PRELIMINARY/FINAL DRAINAGE REPORT

FOR PAINT BRUSH HILLS FILING NO. 14

EL PASO COUNTY, COLORADO

MARCH 2021

PROPOSED DRAINAGE MAP

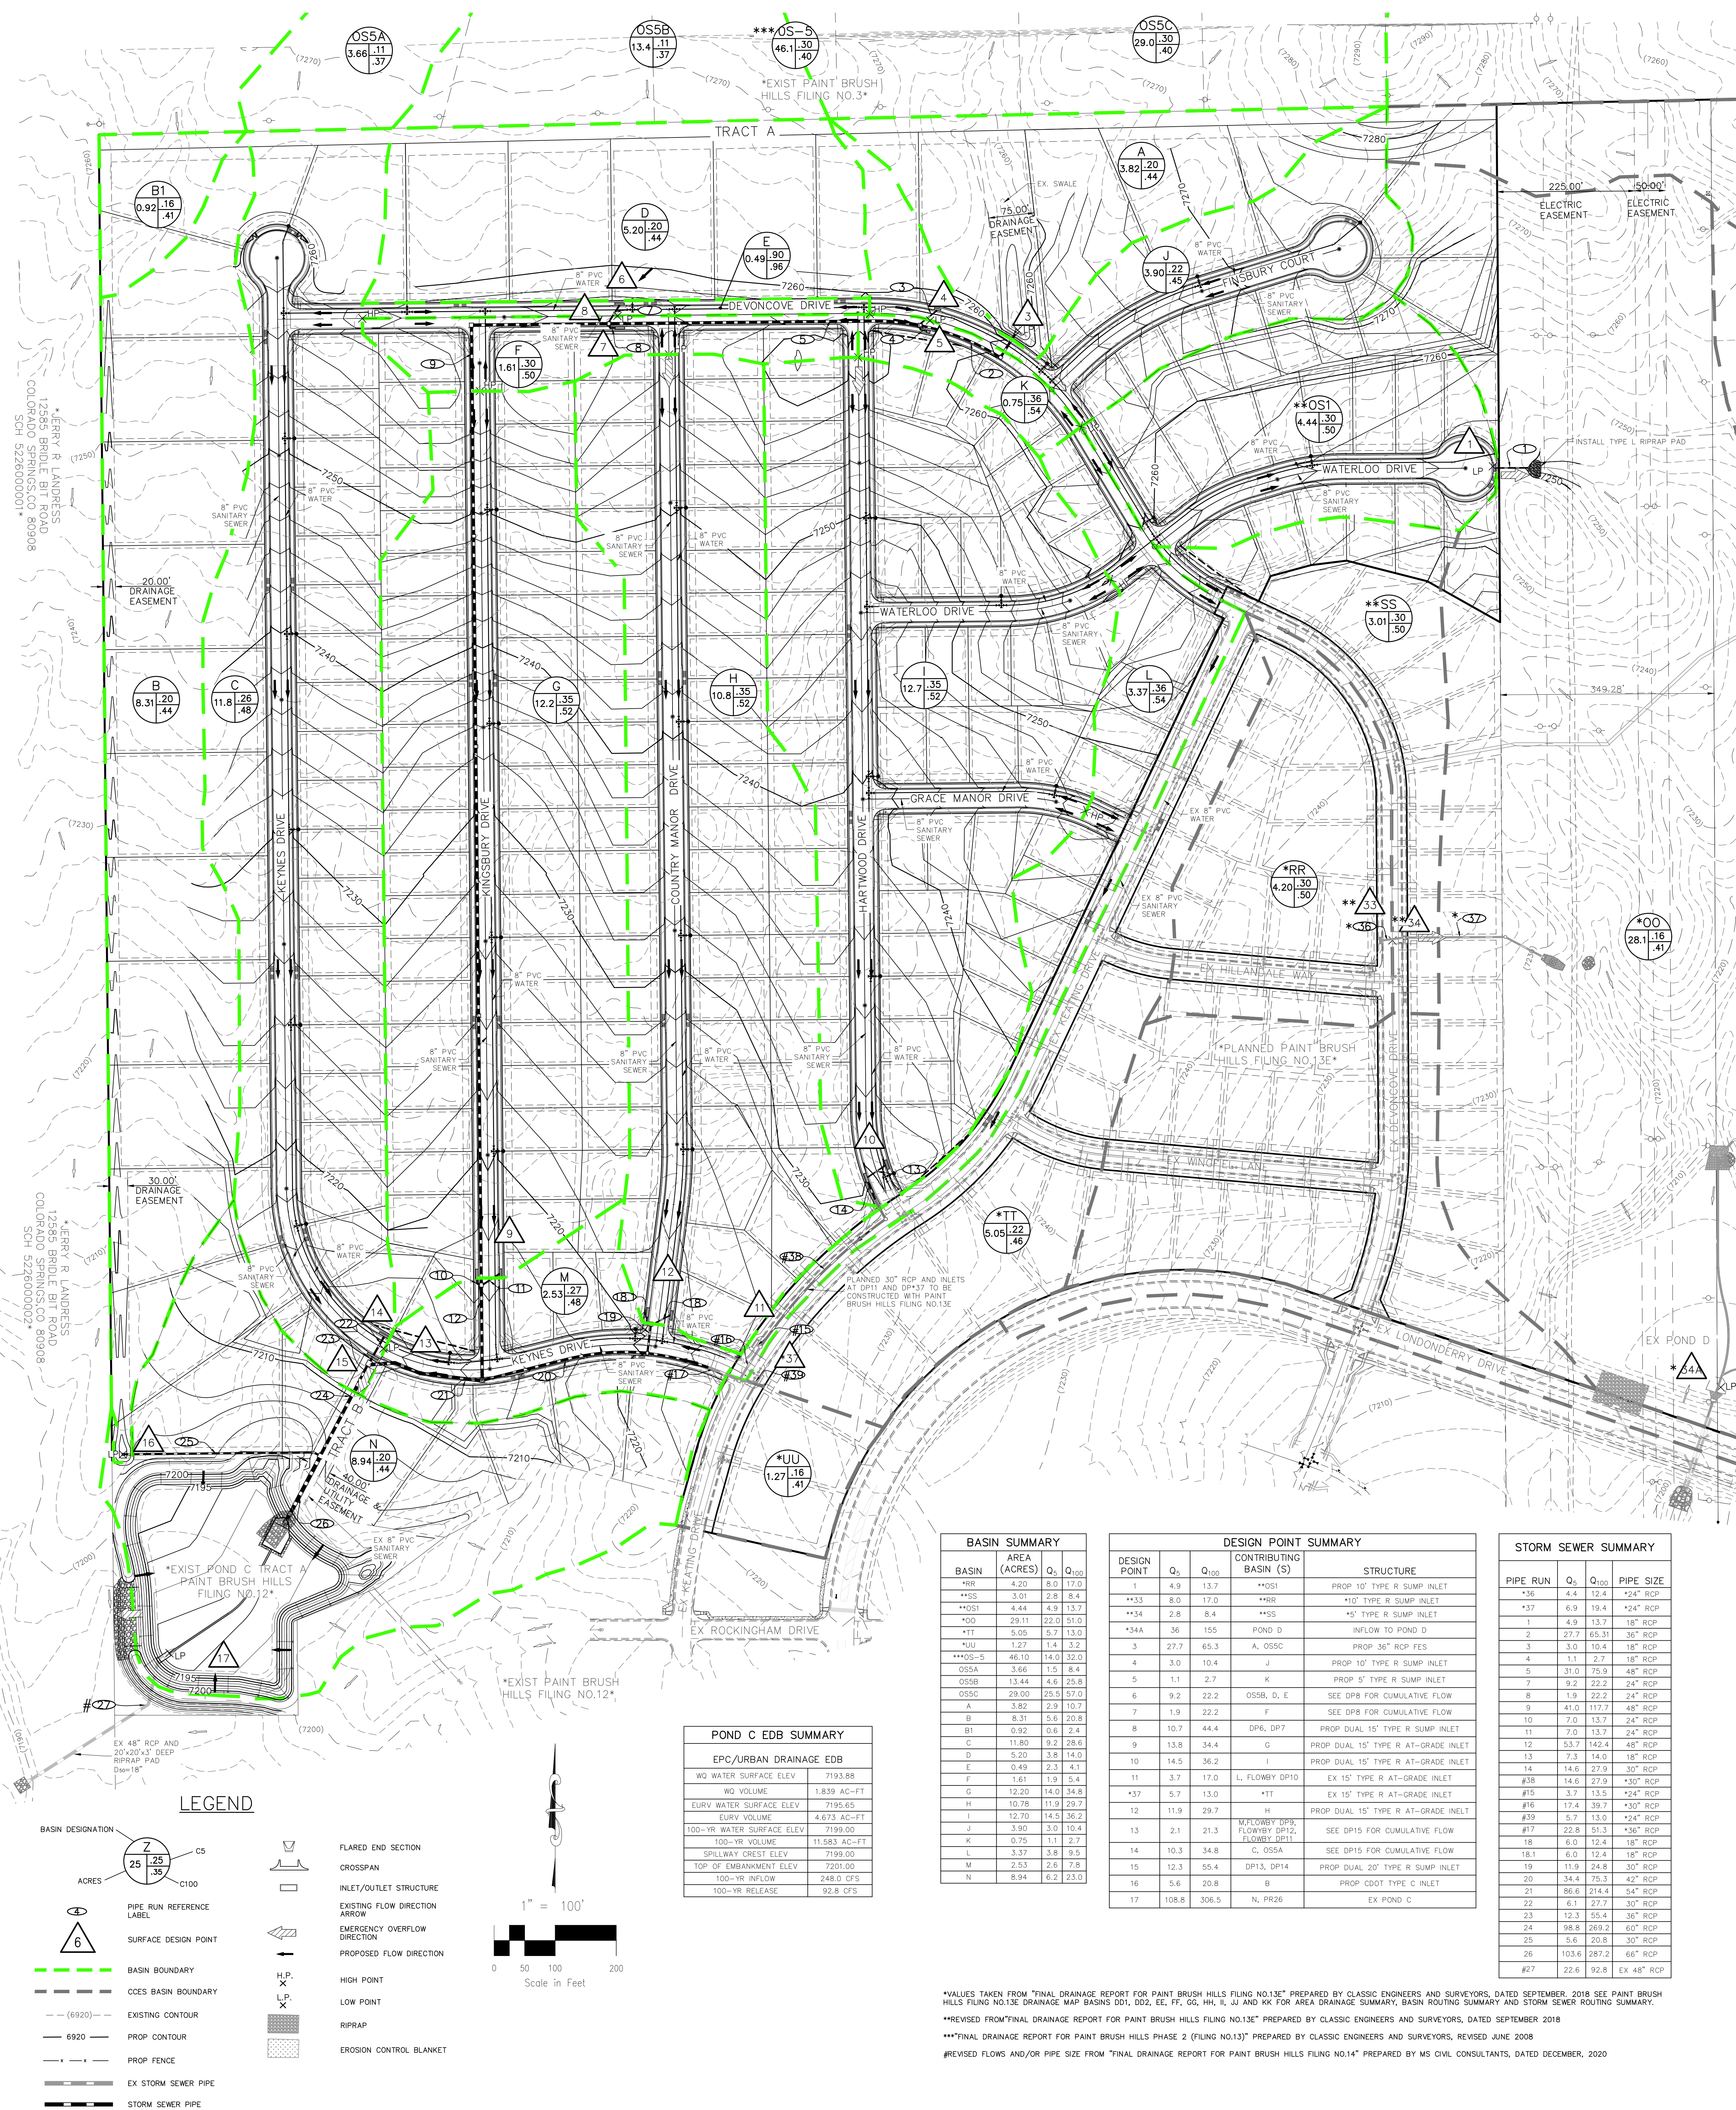
Submittal 2 proposes a swale along the rear of the lots 7 through 18 to address review 1 comment. However, this swale is conveying up to 20 cfs across multiple lots, locate the swale within a tract and identify who is responsible for maintenance. As designed, homeowners will install fencing that would impede flow.

Unresolved. Update narrative to describe the mitigation proposed.

100% of the development site must be treated for water quality. Provide permanent stormwater quality control measure for basin B.

Review 2. Unresolved. See ECM Appendix I Section I.7.1.B and Section I.7.1.C.1.a for exclusion from permanent WQ. Update the narrative to explain/identify the relevant exclusion from permanent water quality. If no exclusion is applicable then original comment remains.

Review 3. Unresolved. Contact the review engineer (Gilbert LaForce) if you require clarification regarding review 2 comments. Update narrative to identify the specific criteria (See ECM I.7.1.C.1.a.) that allows exclusion from permanent WQ for this particular subbasin and include justification in the narrative. In the narrative identify basin B1's percentage of the subdivision.
